Online Comment

Application H17-0504-19
Location Off Stockhouse Lane Surfleet Spalding PE11 4AU
Proposal Erection of dwelling - Outline approval H17-0242-17

PLANNING APPLICATION REFERENCE NO. H17 - 0504 - 19
Off Stockhouse Lane Surfleet Spalding Lincs PE11 4AU

Job Title Proposed Dwelling Land adj. 23 Stockhouse Lane Surfleet, Spalding For Mr & Mrs Bennett	Date July 2019	Drawn by GG Checked by GE
Drawing Title Planning Drawing Site Plan and Location Plan	Job No. SE-1163 Dwg No. PP1000	Sheet Size A1 Revision 06

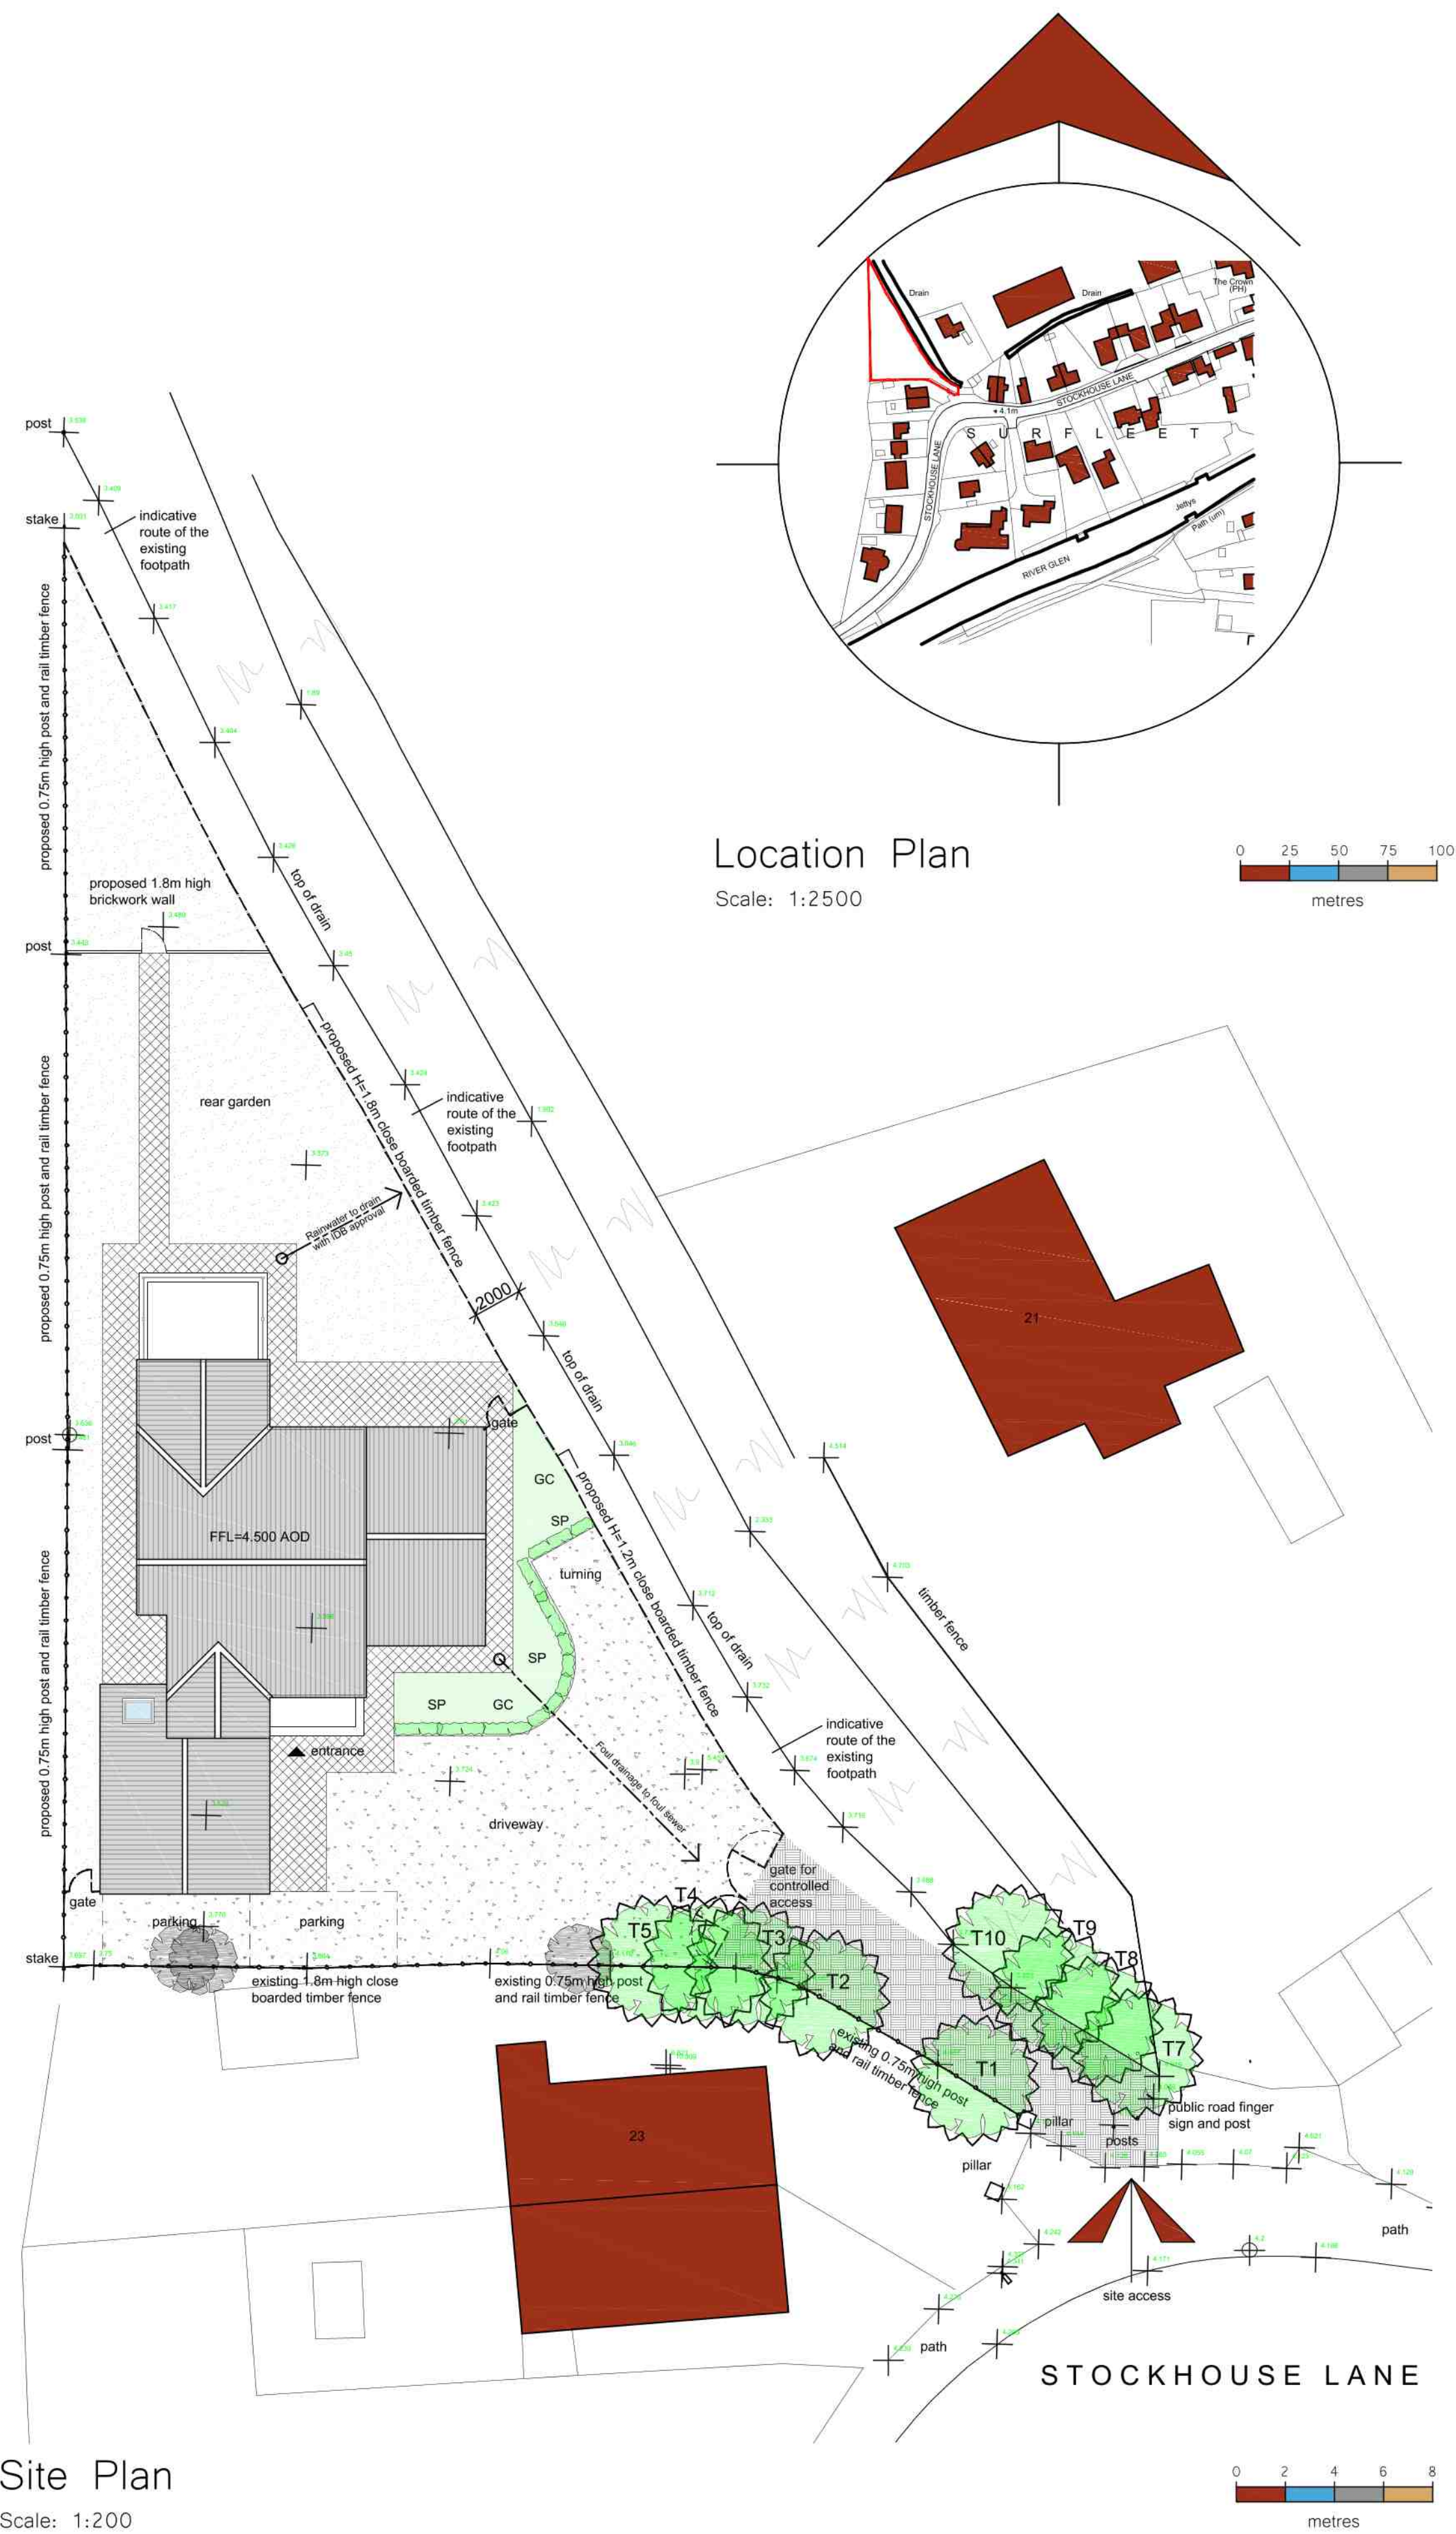
The proposed development affects Surfleet Public Footpath No. 5.

- i/ It is expected that there will be no encroachment, either permanent or temporary, onto the right of way as a result of the proposal.
- ii/ A minimum width of 2m should be retained to accommodate the public footpath. It is not desirable to install a fence between the drain and the public footpath as this will make the footpath feel enclosed.
- iii/ No gates should be erected across the public footpath or gates posts erected at either side of the public footpath.
- iv/ No surfacing works shall take place on the section of public footpath which runs along the driveway until a specification has been agreed with Lincolnshire County Council.
- v/ The proposed development should not pose any dangers or inconvenience to the public using the right of way.
